Our Reference: SYD18/01322/25

Departments Reference: SSD 9522

RESPONSE TO SUBMISSIONS ADDENDUM - KEMPS CREEK WAREHOUSE, LOGISTICS AND INDUSTRIAL FACILITIES HUB (SSD 9522)

TURNING PATHS
A-DOUBLE - RIGHT OUT

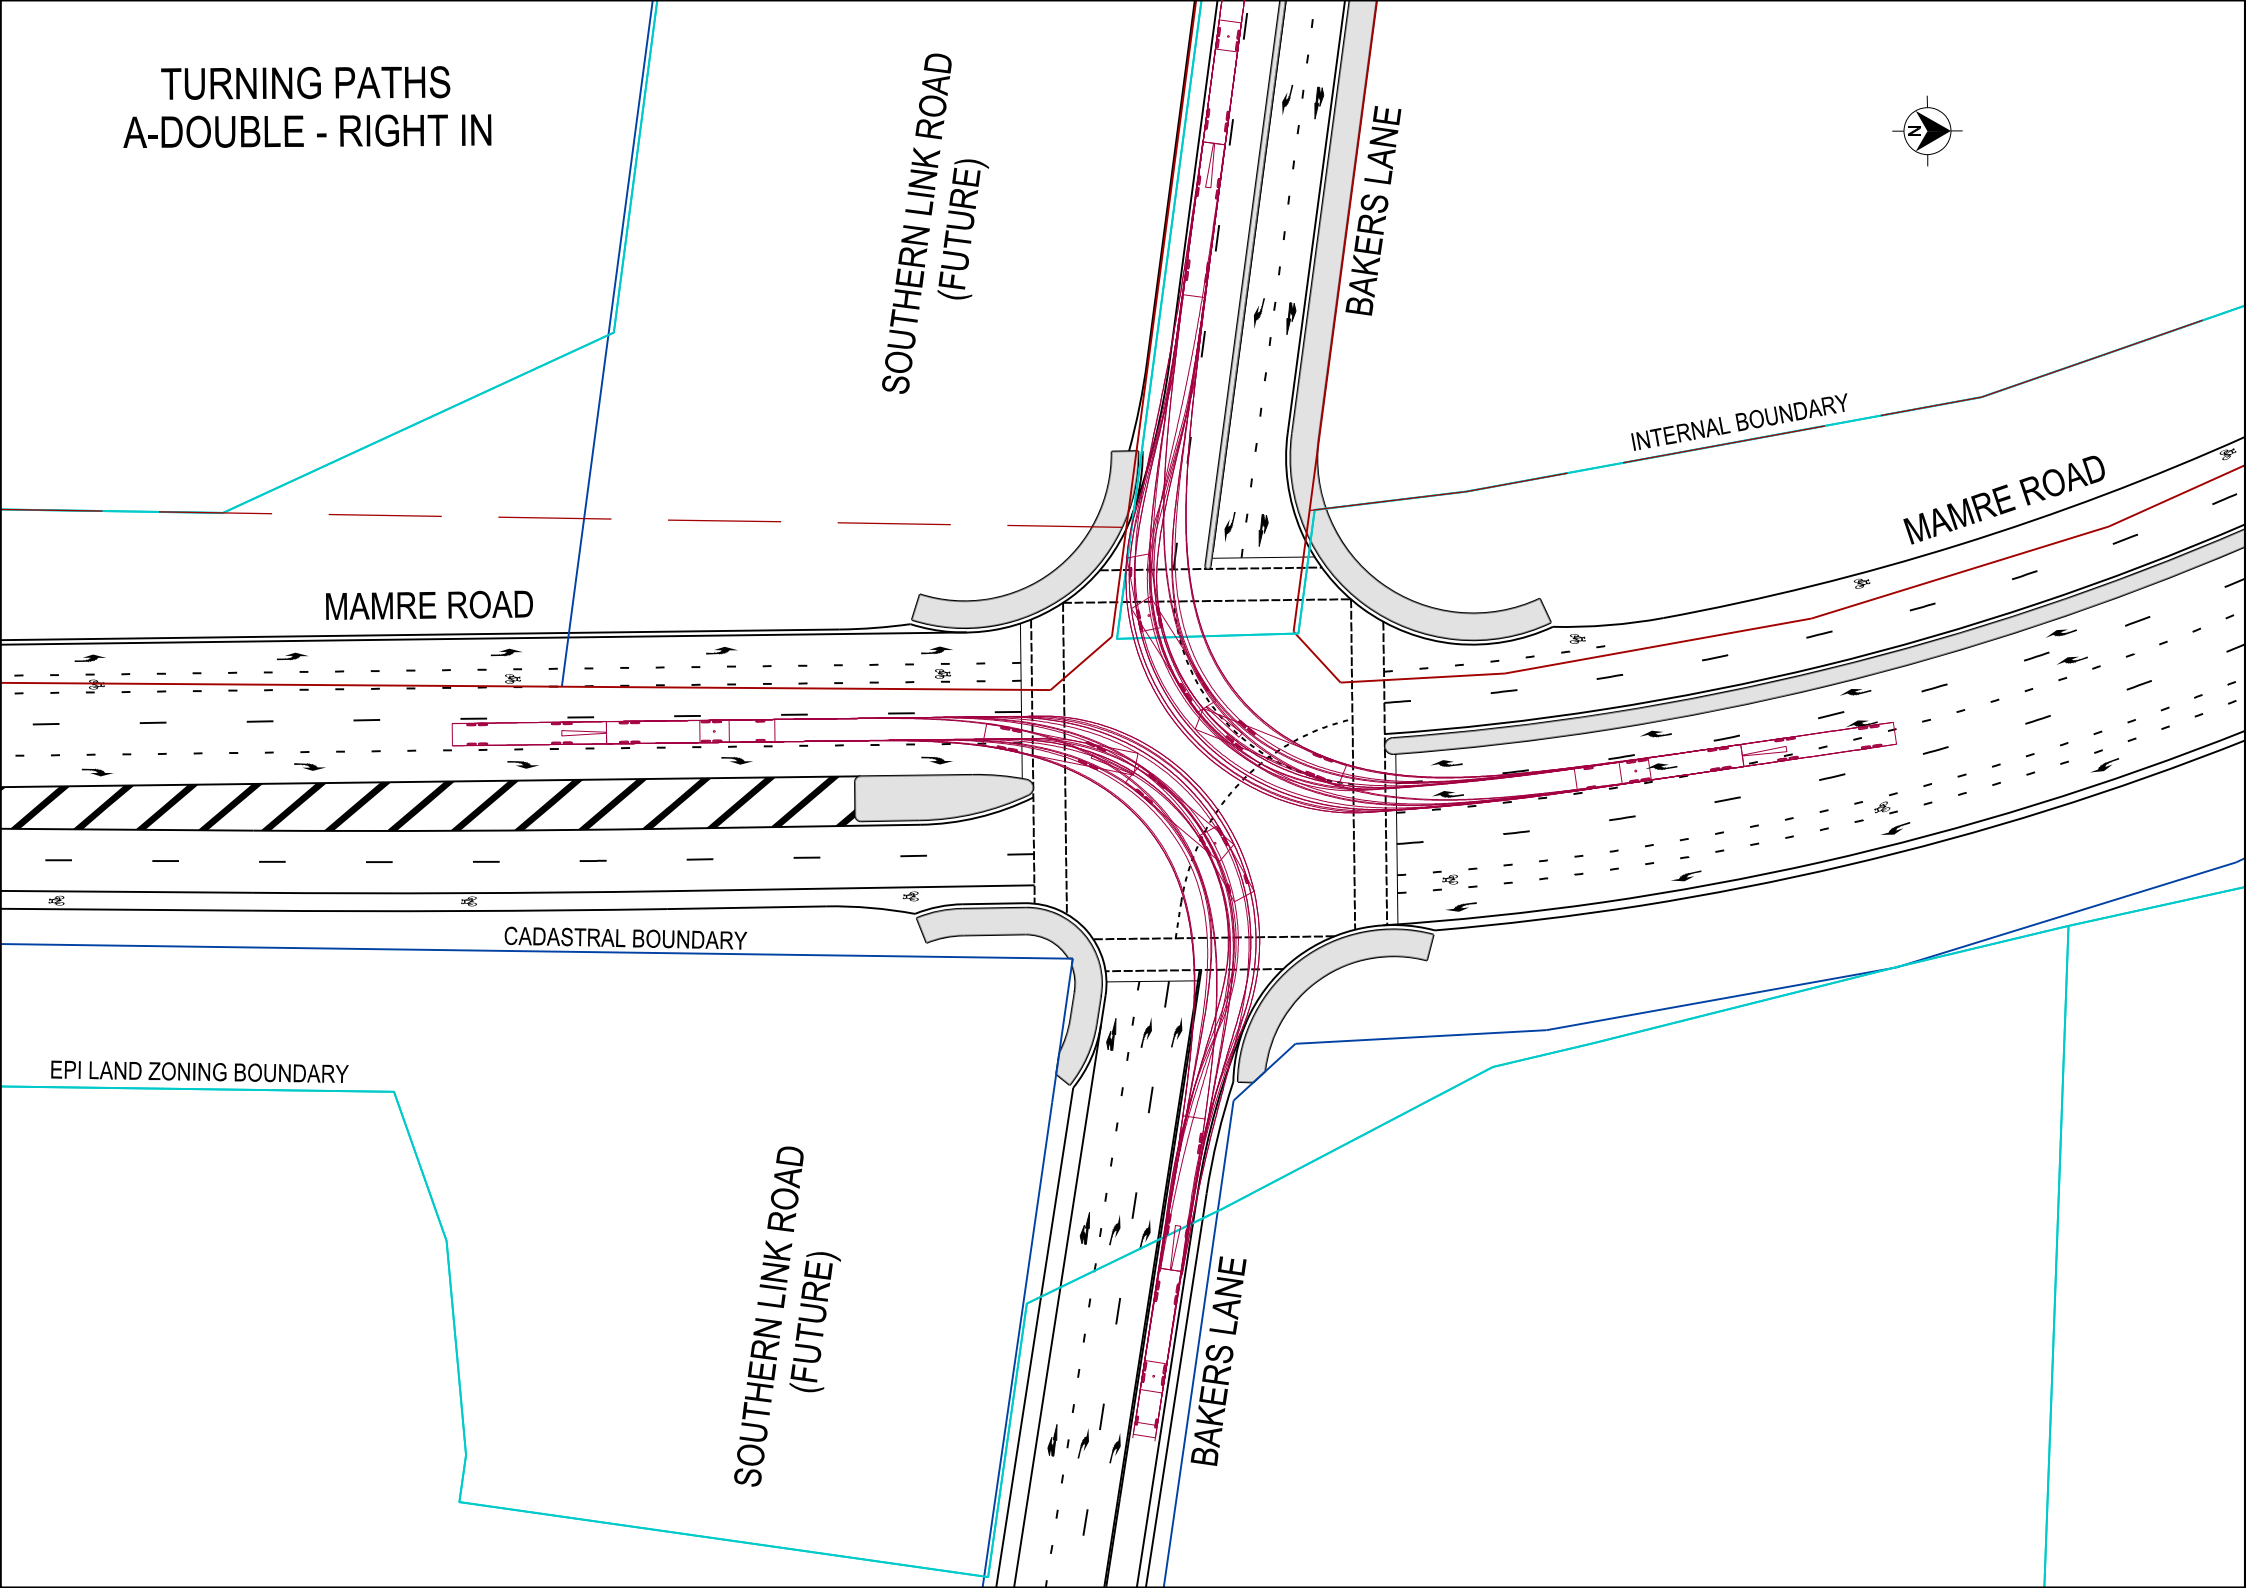
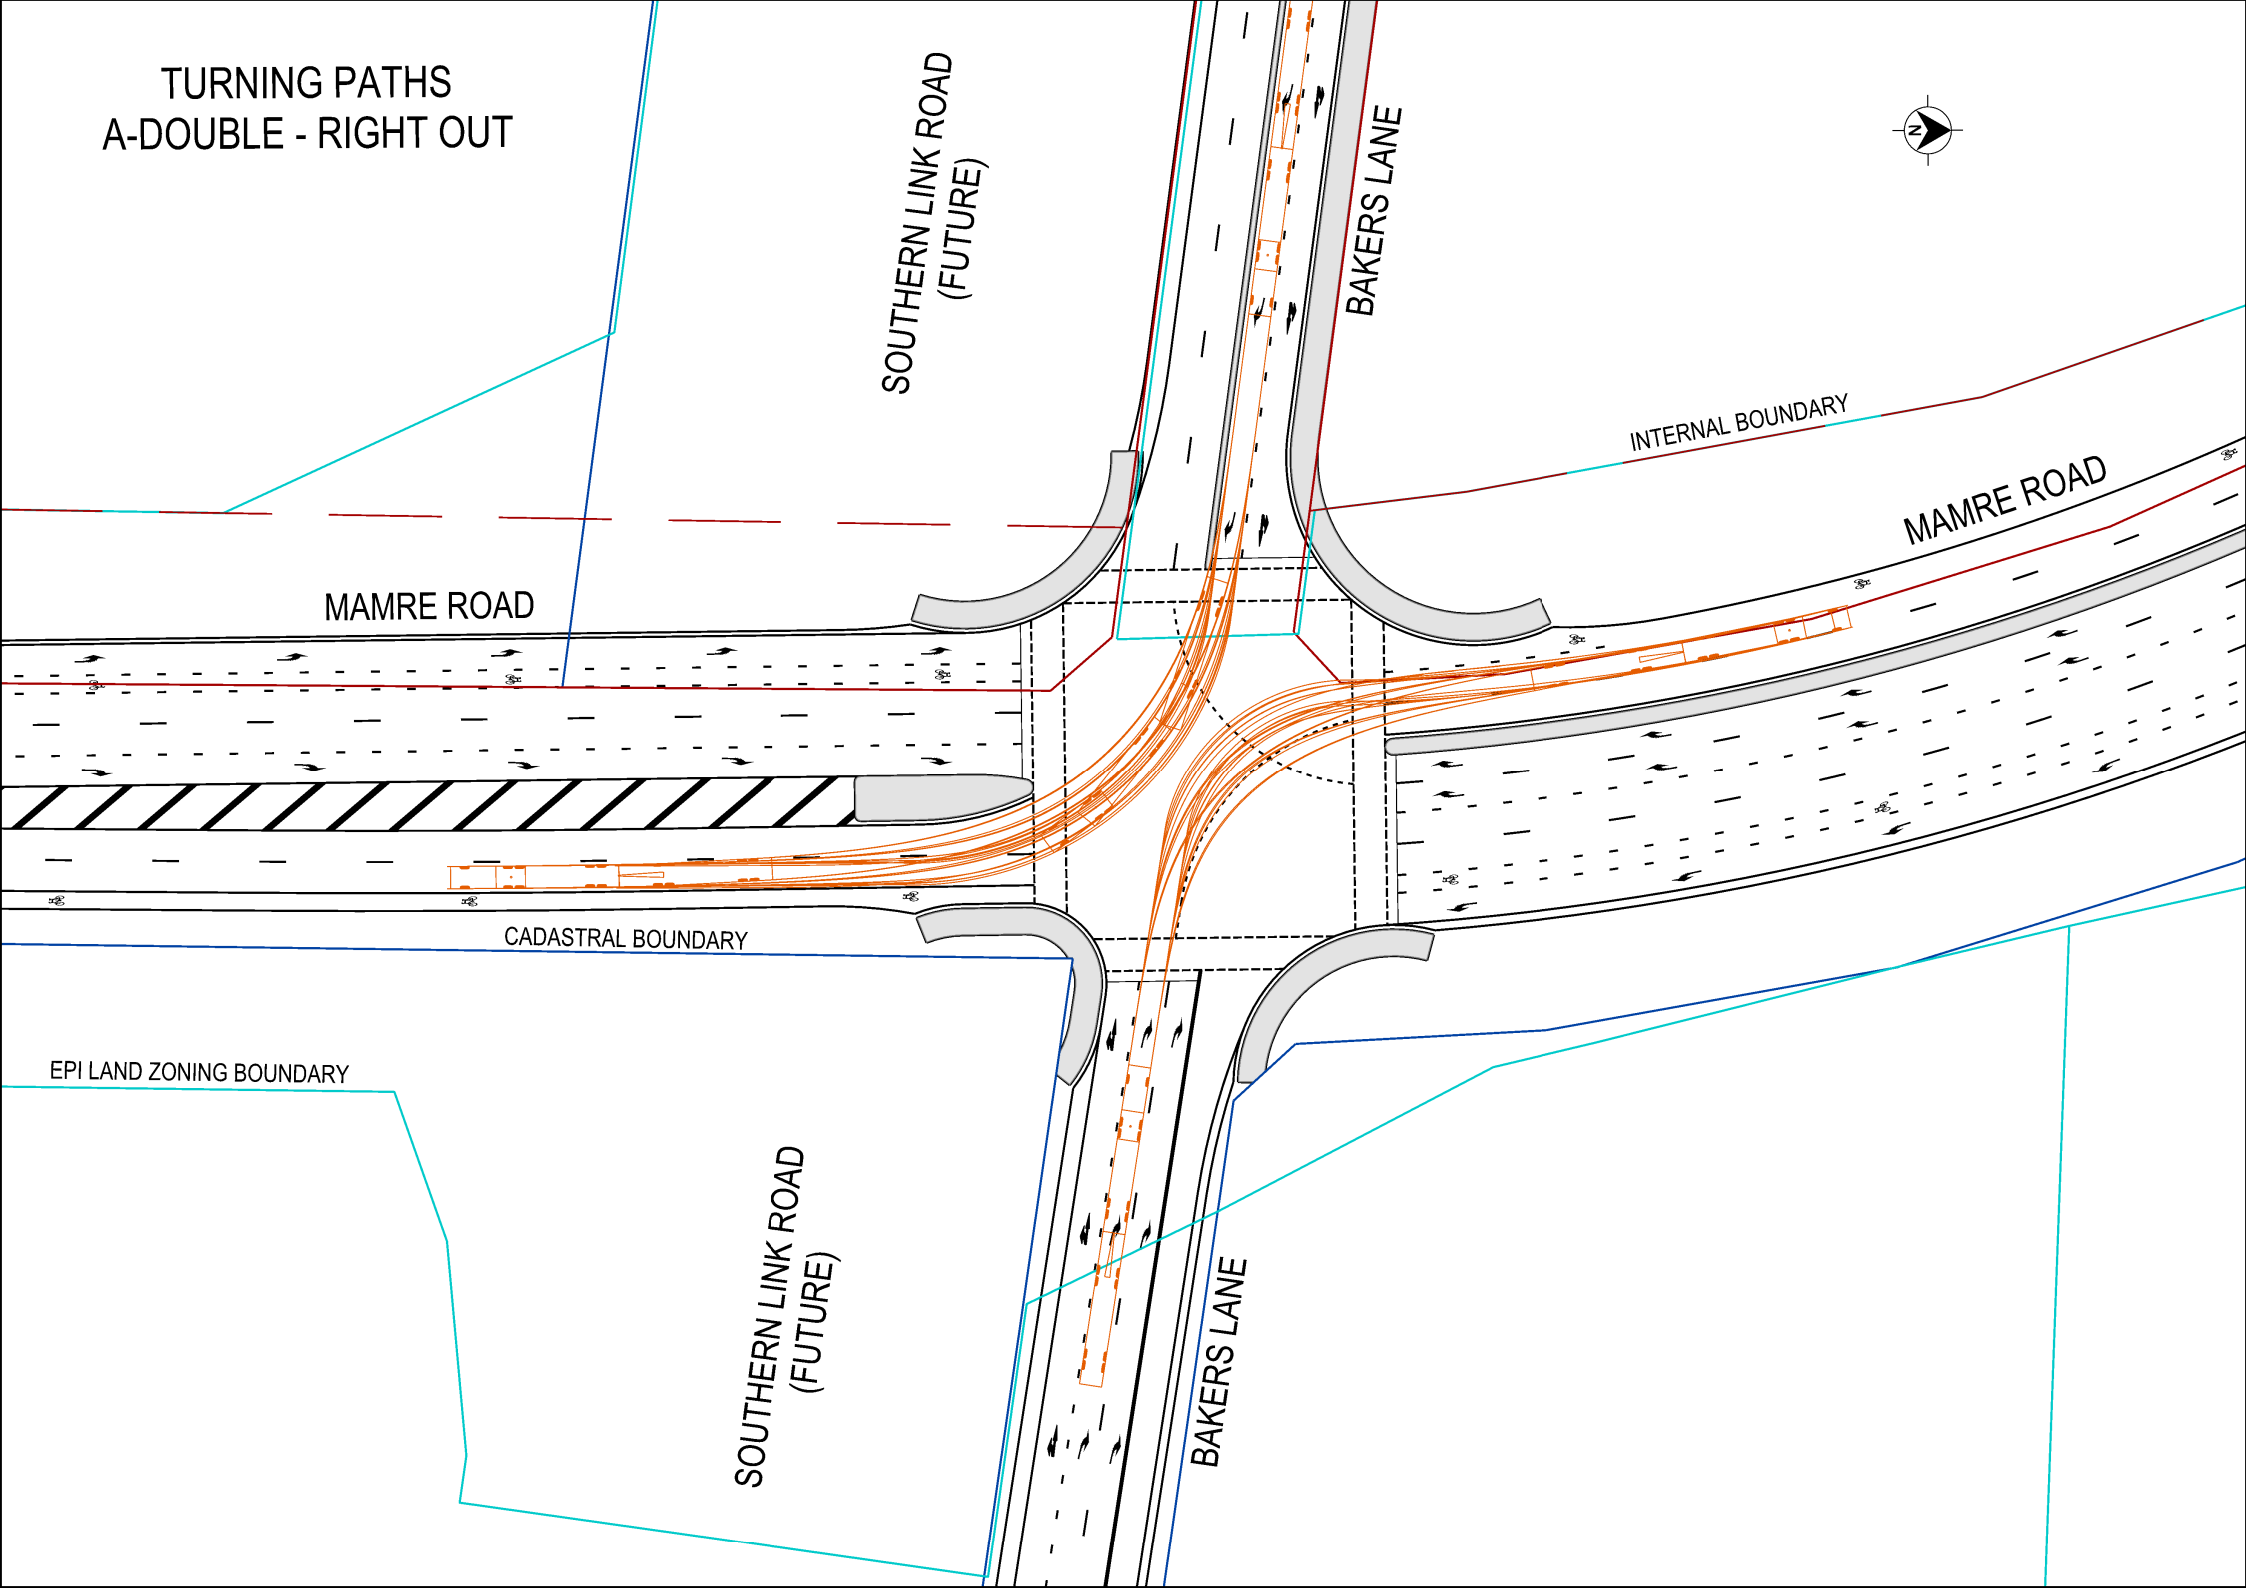
- The eastern section of Bakers lane is not a B-double route therefore the abovementioned design for the eastern leg accommodates for a 19 metre Semi-Trailer with a checking vehicle of a B-double. An A-double cannot be achieved and will require further upgrades to the signalised intersection should the eastern section of Bakers Lane be changed to a B-double or A-double route to accommodate future developments to the east. This is not provided under this development application which is located on the western side of Mamre Road;
